**A47 NORTH TUDDENHAM TO EASTON (THE “PROJECT”)
DEADLINE 1 – 1 SEPTEMBER 2021
NATIONAL GRID GAS PLC**

2. DIVERSION OF THE HIGH PRESSURE GAS PIPELINE

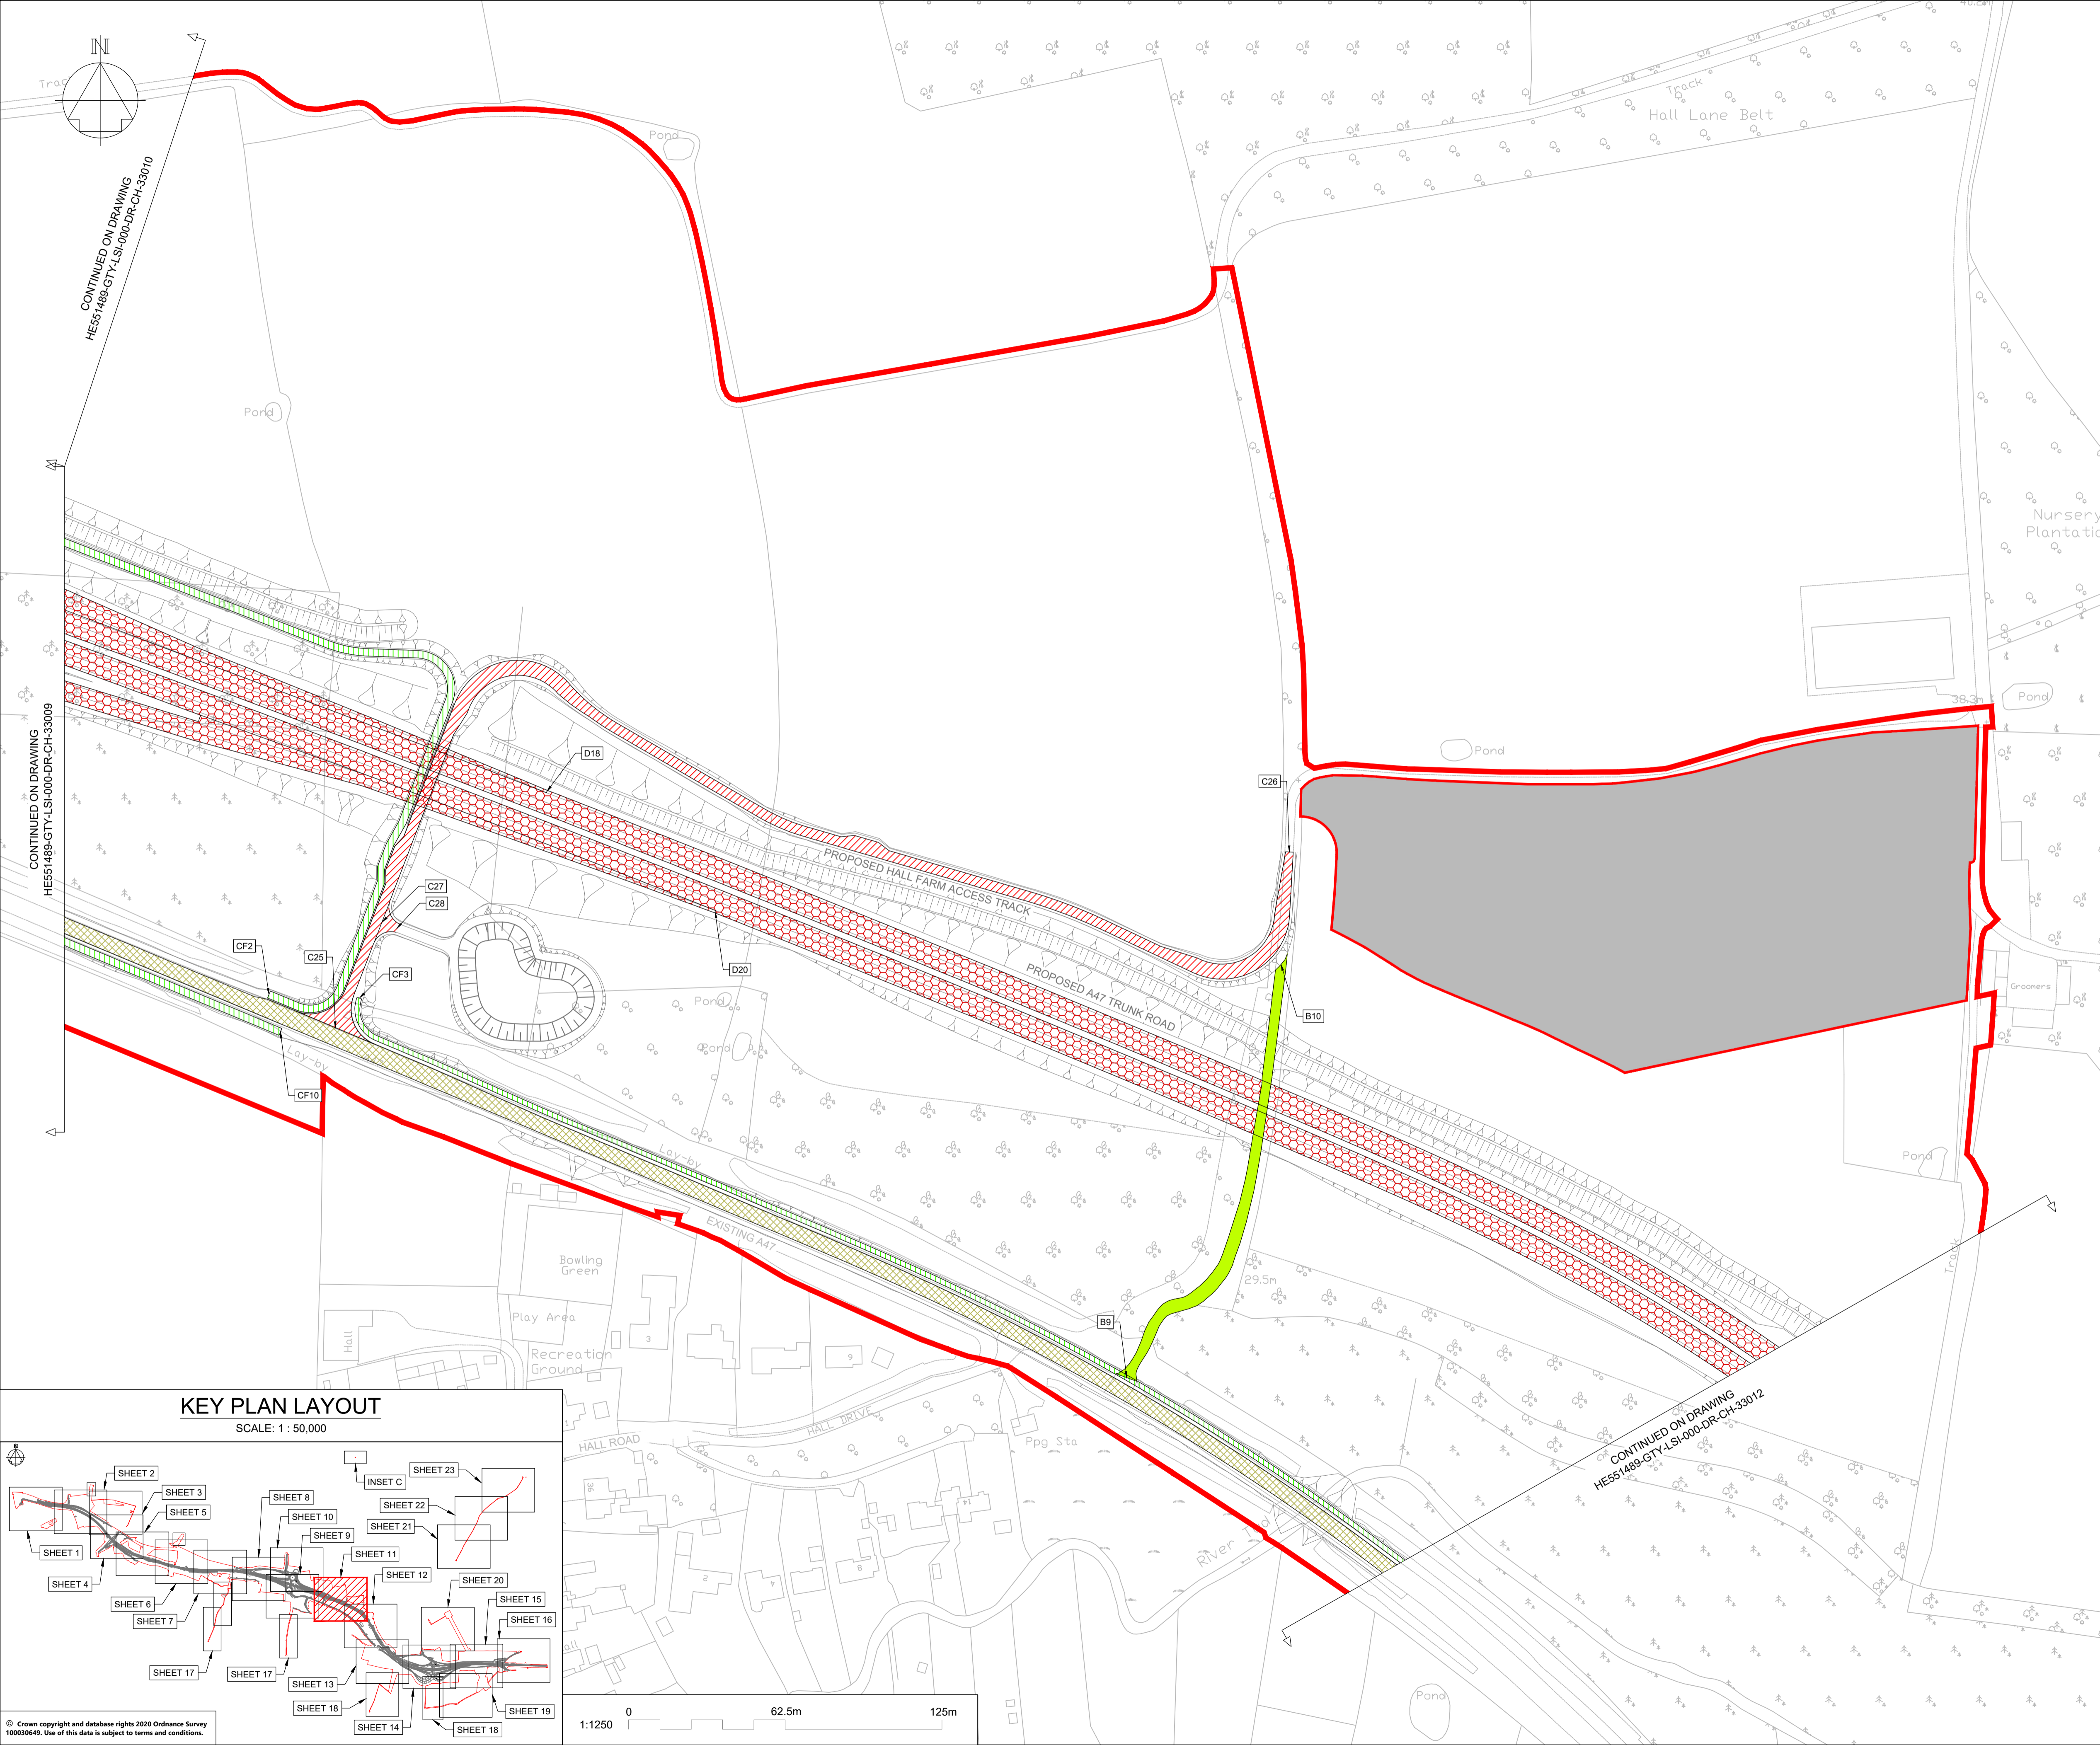
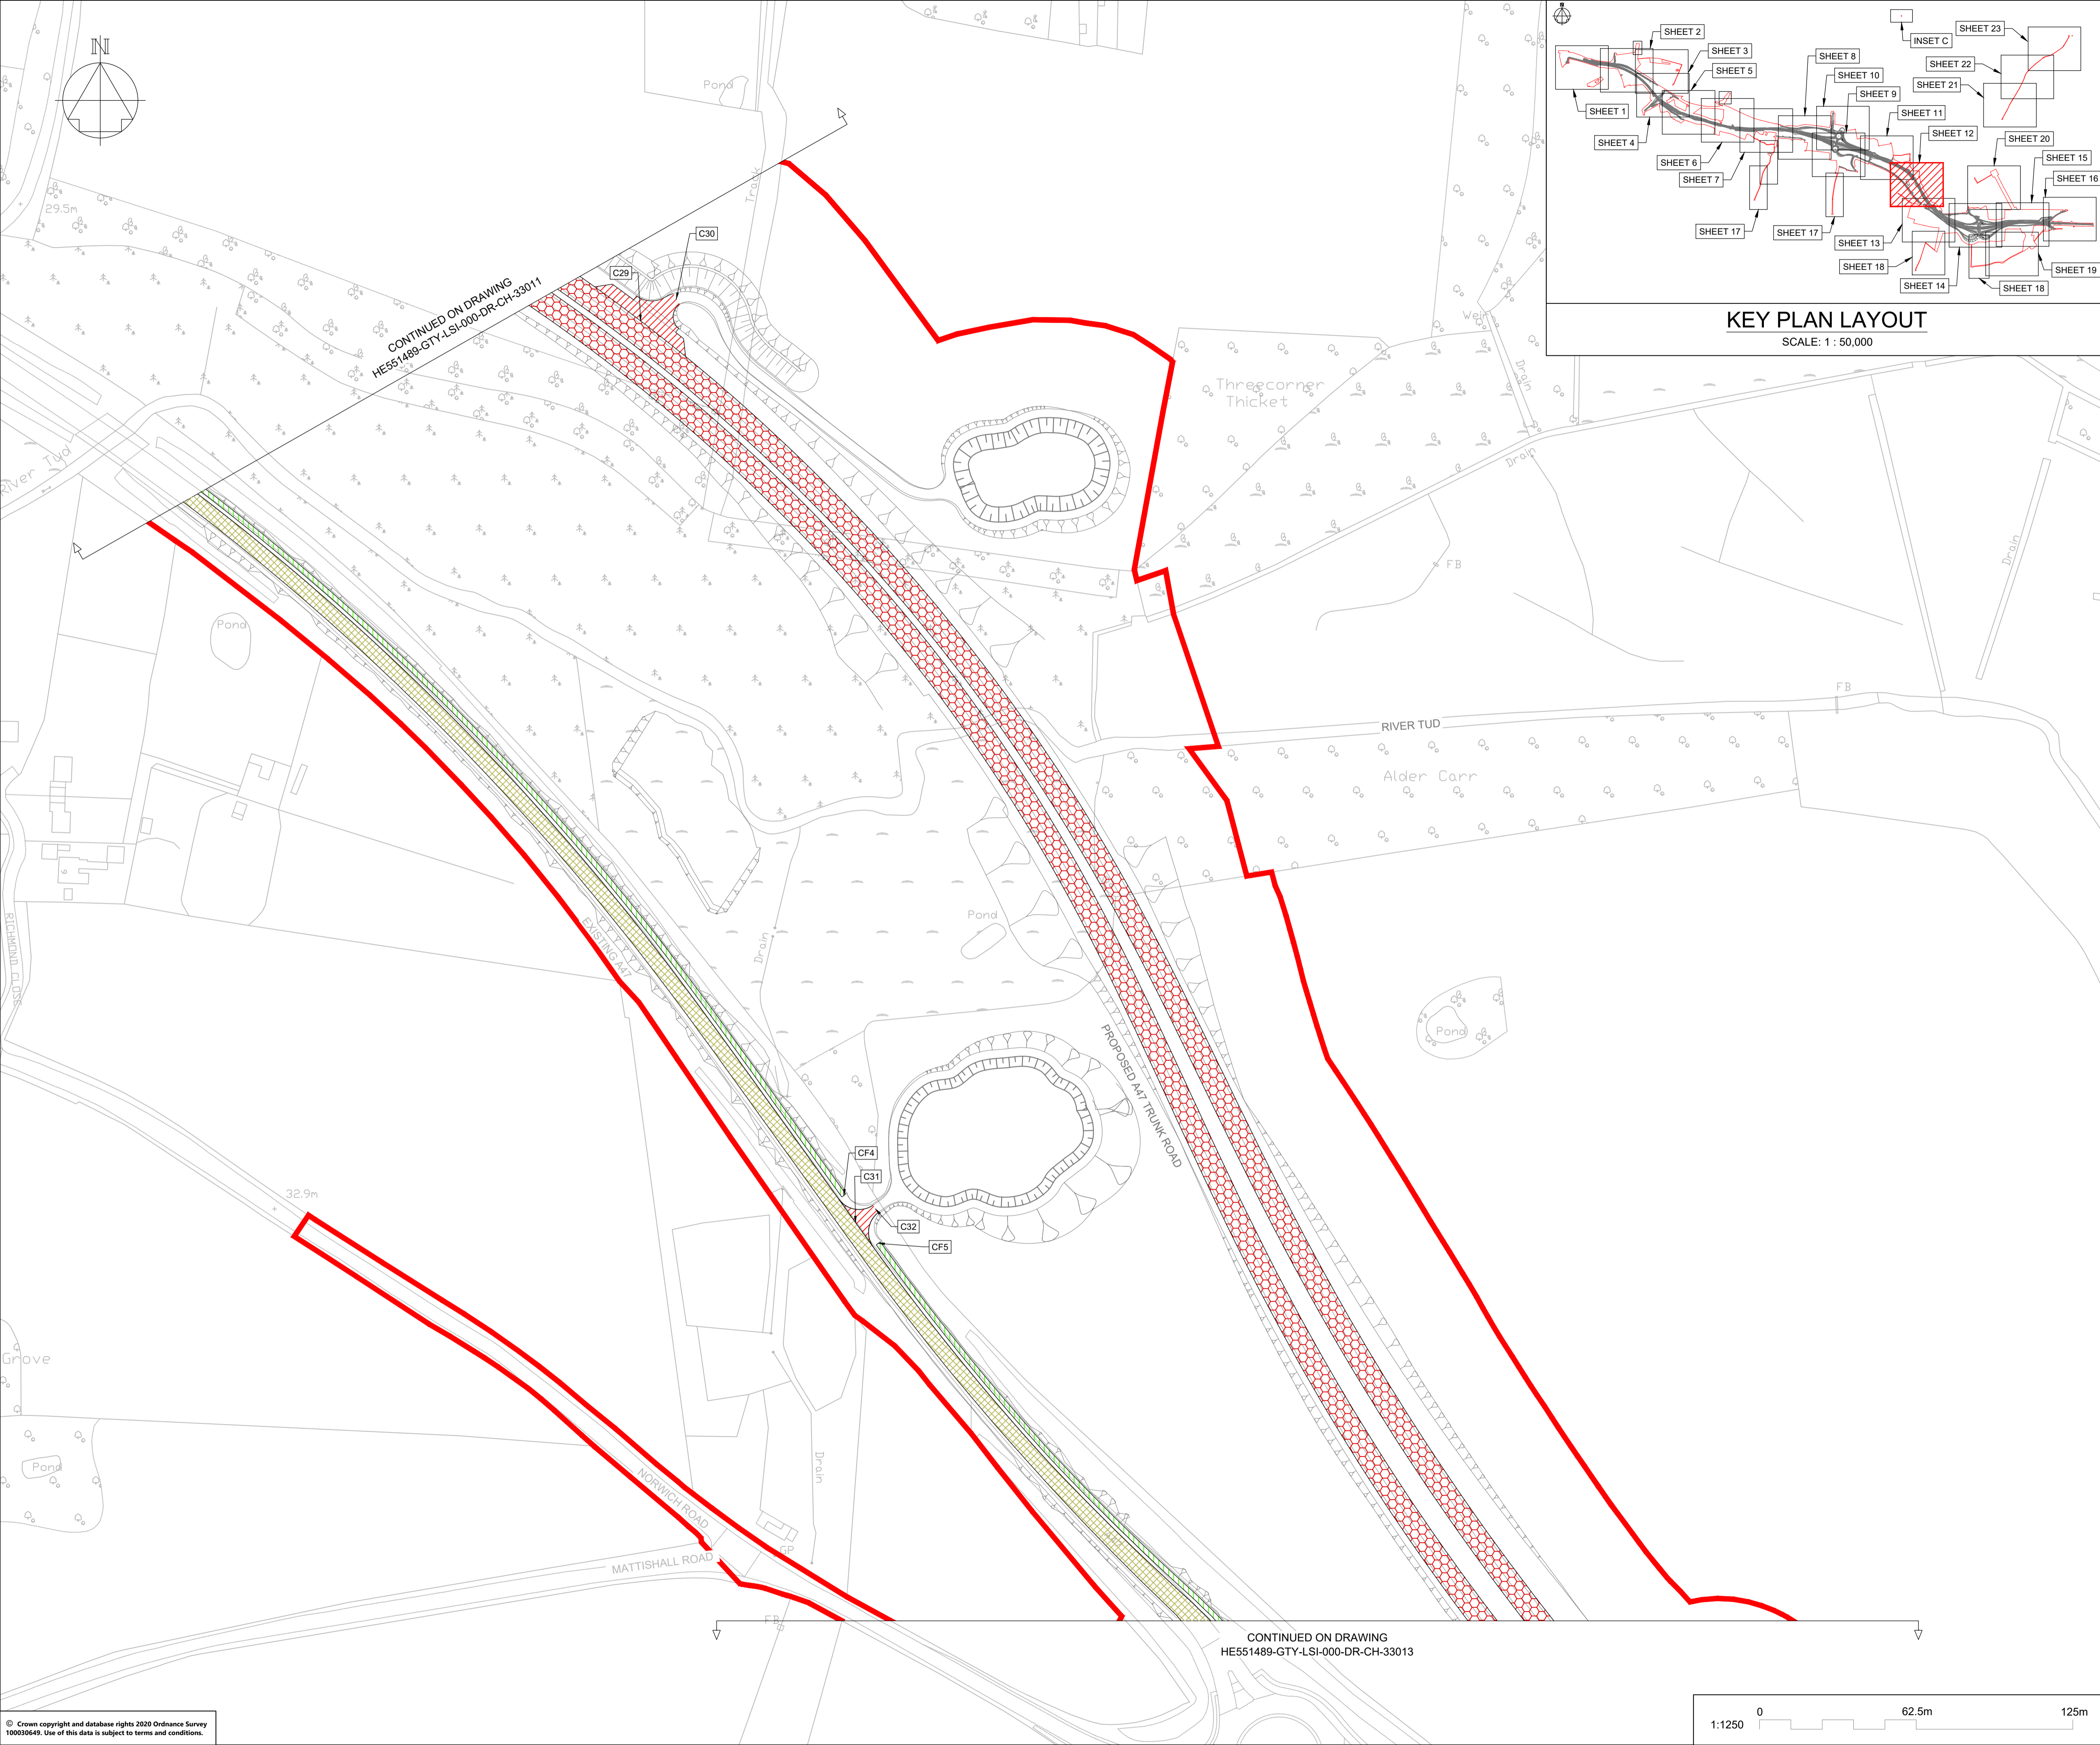
- 2.2 Work No. 84 is for the “*diversion of a high pressure gas pipeline, potable water pipeline and overhead electronic communications and low voltage electricity utility cables along Wood Lane, the existing A47, Berrys Land and Dereham Road, Honingham, affected by Works Nos. 1, 17, 18, 29, 24, 26, 27, 28 and 32 shown on sheet numbers 9 and 10 of the works plans*”. This is the High Pressure Gas Pipeline.

- 2.3 NGG is currently liaising with the Promoter regarding the extent of the land required for the diversion of the High Pressure Gas Pipeline.
- 2.4 NGG is also liaising with the Promoter regarding the access that is currently proposed to facilitate the diversion. The field where the HDD apparatus will be located will require a better access than the existing farmer’s access provides. This is because (a) there are overhead cables that cross in parallel to Berry’s Lane; and (b) there will be a steady flow of tankers in and out transporting bentonite and the treated arisings from the drill will also need to be removed. The proposed access is not suitable for the type and volume of traffic required.

- 2.5 NGG and the Promoter will continue to work together to resolve these points and NGG will update the ExA as to progress at subsequent deadlines.
